RELEVANT COMMENTS FROM
PREVIOUS OFFICER REPORT
AND FROM APPEAL INSPECTOR'S
DECISION:

JOB TITLE:
89 WARWICK CRESCENT HAYES

PROPOSED BLOCK / ROOF PLAN (SCALE 1:200)

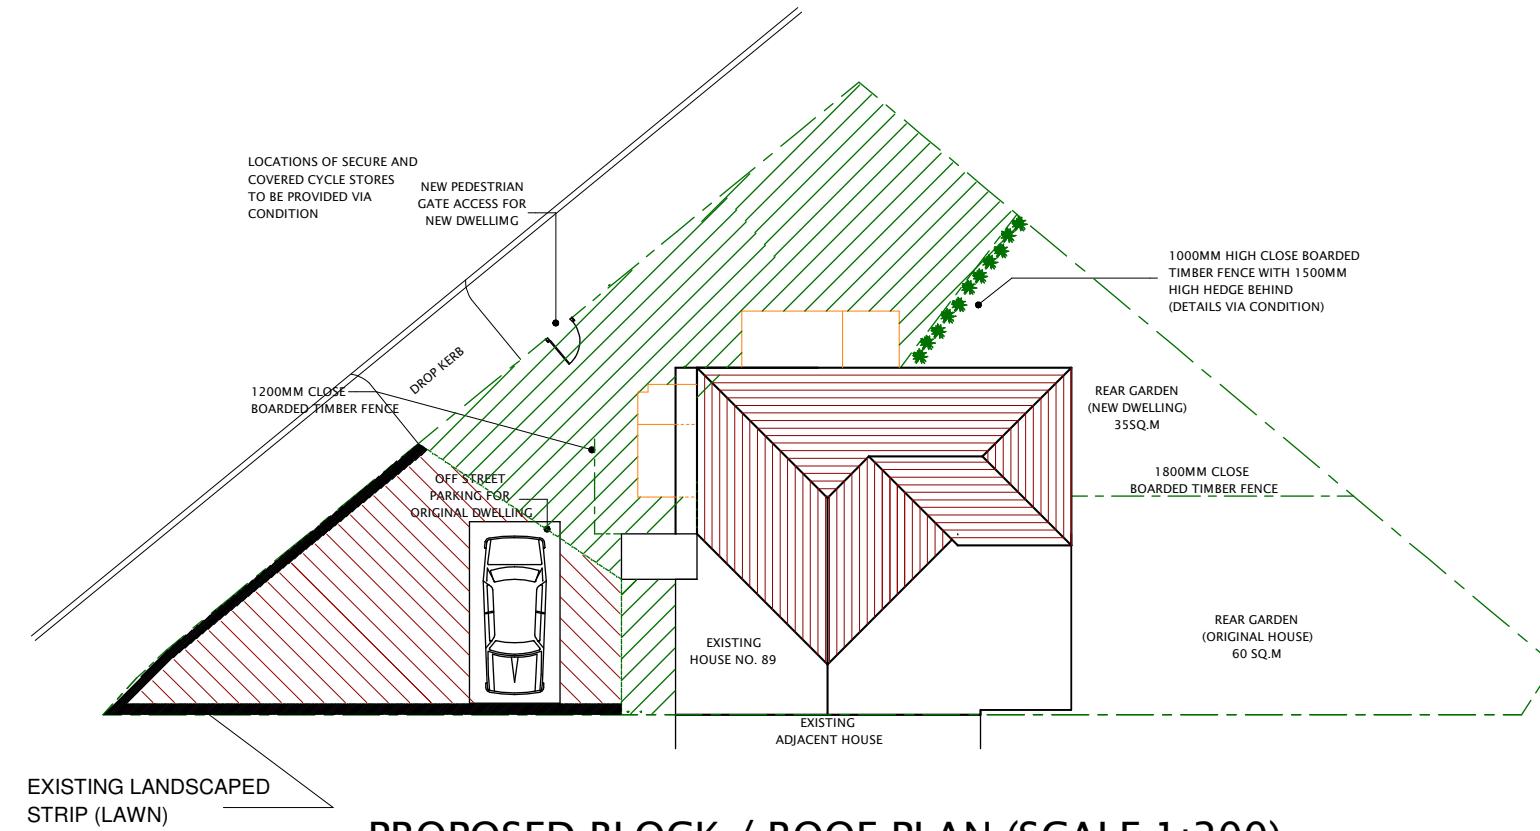
10. The Council is also concerned about a reduction in spaciousness and a breach of the return building line in Warwick Crescent. I saw that the greater spaciousness at the corner plots is a positive feature that helps to offset the high density of built development in the area. That said, there is some inconsistency in the spacing due to various extensions that have taken place at these corner plots over time. Crucially, the gap between the appeal site and 87 Warwick Crescent is more spacious than most, even with the existing single-storey side extension. This is in part due to the access lane that runs in-between the properties.

11. The drawings indicate that ample space would be retained around the building and to the property boundaries, such that the development would not appear cramped or overdeveloped within the plot. Moreover, any breach of the return building line would be very marginal and thus of little consequence, particularly given the curvature of the road and that the host building sits on an entirely different alignment to the dwellings in Warwick Crescent. I am therefore content that the development would not be unduly intrusive or incongruous in terms of its scale and design.

DATE	REVISION
COPYRIGHT:	
JOB TITLE: 89 WARWICK CRESCENT HAYES	
DRAWING TITLE: PROPOSED GROUND FLOOR PLAN, FIRST FLOOR PLAN AND BLOCK PLAN	
SCALE : 1:100	
DATE: 21062024 DRAWN BY:	
DRG. NO. 2021/89/WCH/4003/A	REV.

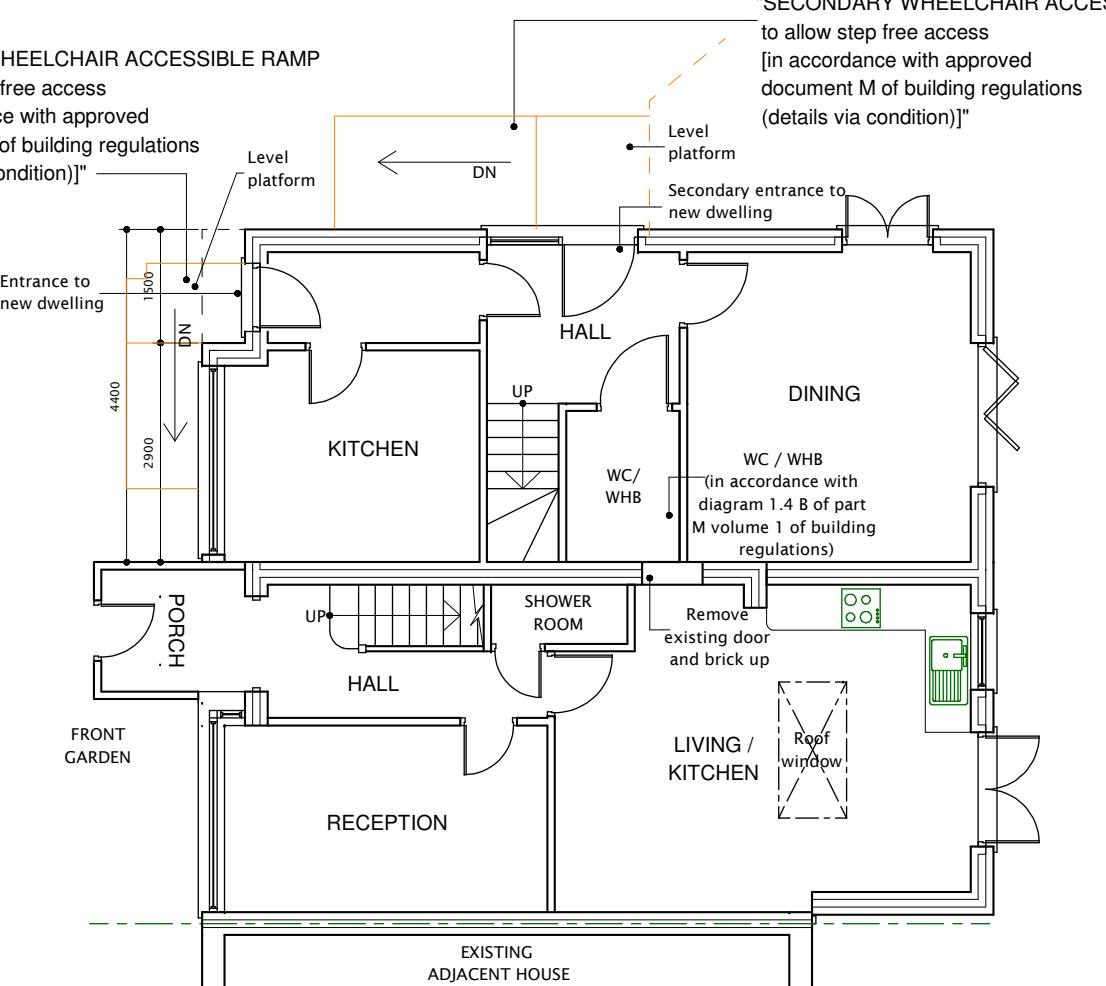
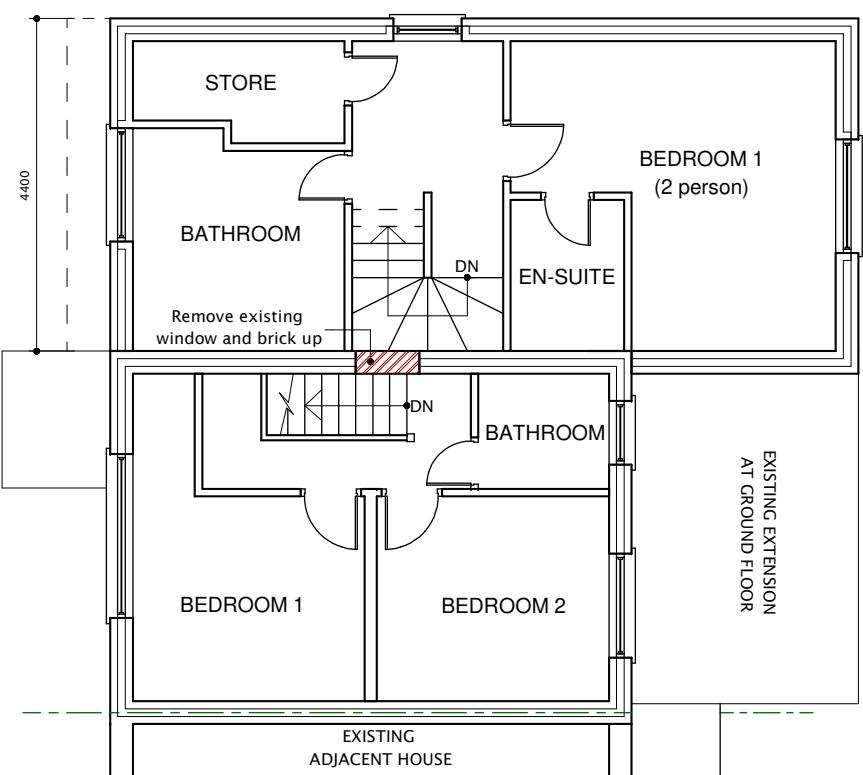
For the new unit proposal to satisfy policy DMT6 secure and covered cycle parking spaces based on 1 per 1 or 2 bed unit should be provided. No cycle storage has been indicated/shown by the applicant. The HA believes that there is sufficient scope for the applicant to satisfactorily address the cycle requirement and therefore could be conditioned.

25. The drawings are annotated to show a 'wheelchair accessible ramp', but this would be to a secondary door at the side of the house rather than the principal access. To my mind, this would be rather undignified for a disabled user. Furthermore, there is a lack of any specific detail on its design and layout, as well as how other doors to outdoor spaces would provide step-free access. I have considered whether the matter could be addressed by a planning condition, but I cannot be certain that any works to achieve compliance would not raise fresh considerations, particularly in respect of the external appearance of the development and parking layout. As such, a condition would not be appropriate.
